EPC STORMWATER REVIEW COMMENTS
 IN ORANGE BOXES WITH BLACK TEXT

EL PASO COUNTY STORMWATER MANAGEMENT PLAN CHECKLIST

Revised: October 2021

PEERLESS FARMS  
EL PASO COUNTY, COLORADO  
COVER SHEET  
CONSTRUCTION DOCUMENTS

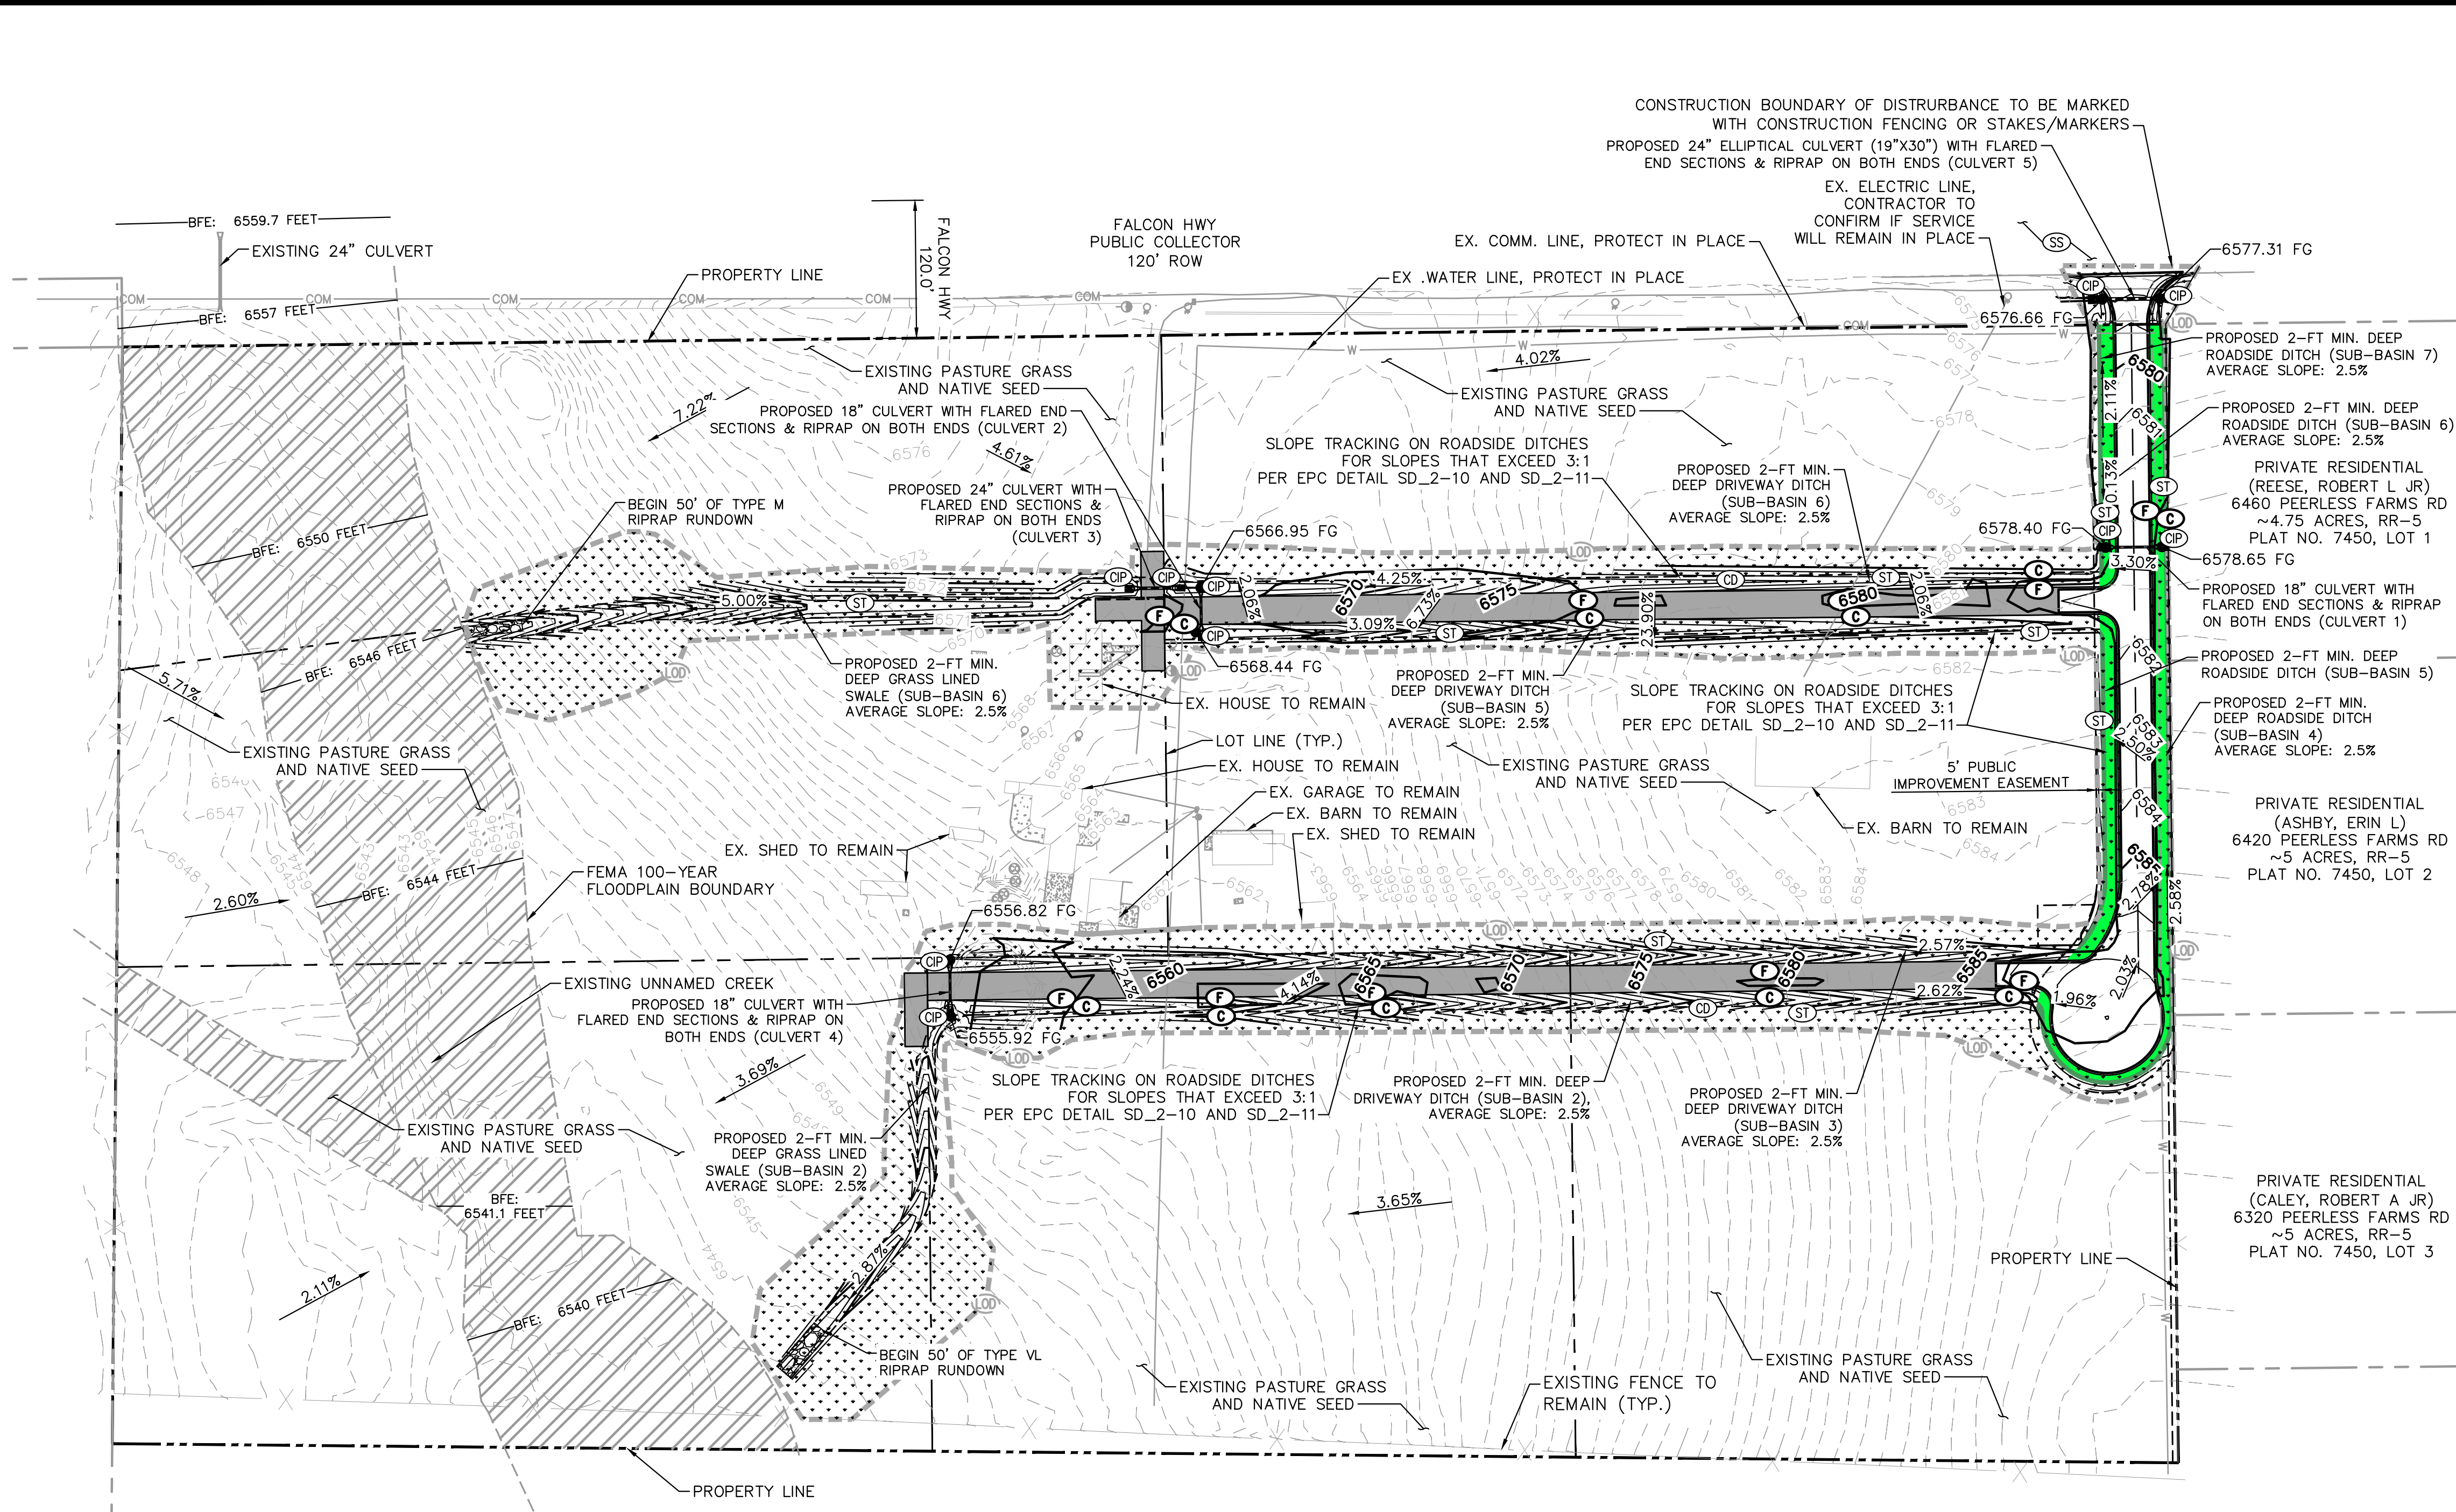
20	Technical drawing details for all control measure installation and maintenance: custom or other jurisdiction's details used must meet or exceed EPC standards See GEC Plan comments		N
21	Procedure describing how the SWMP is to be revised		Y
22	Description of Final Stabilization and Long-term Stormwater Quality (describe nonstructural and structural measures to control SW pollutants after construction operations have been completed, including detention, water quality control measure etc.)		Y
23	Specification that final vegetative cover density is to be 70% of pre-disturbed levels		Y
24	Outline of permit holder inspection procedures to install, maintain, and effectively operate control measures to manage erosion and sediment		Y
25	Record keeping procedures identified to include signature on inspection logs and location of SWMP records on-site		N
26	If this project relies on control measures owned or operated by another entity, a documented agreement must be included in the SWMP that identifies location, installation and design specifications, and maintenance requirements and responsibility of the control measure(s)		Y
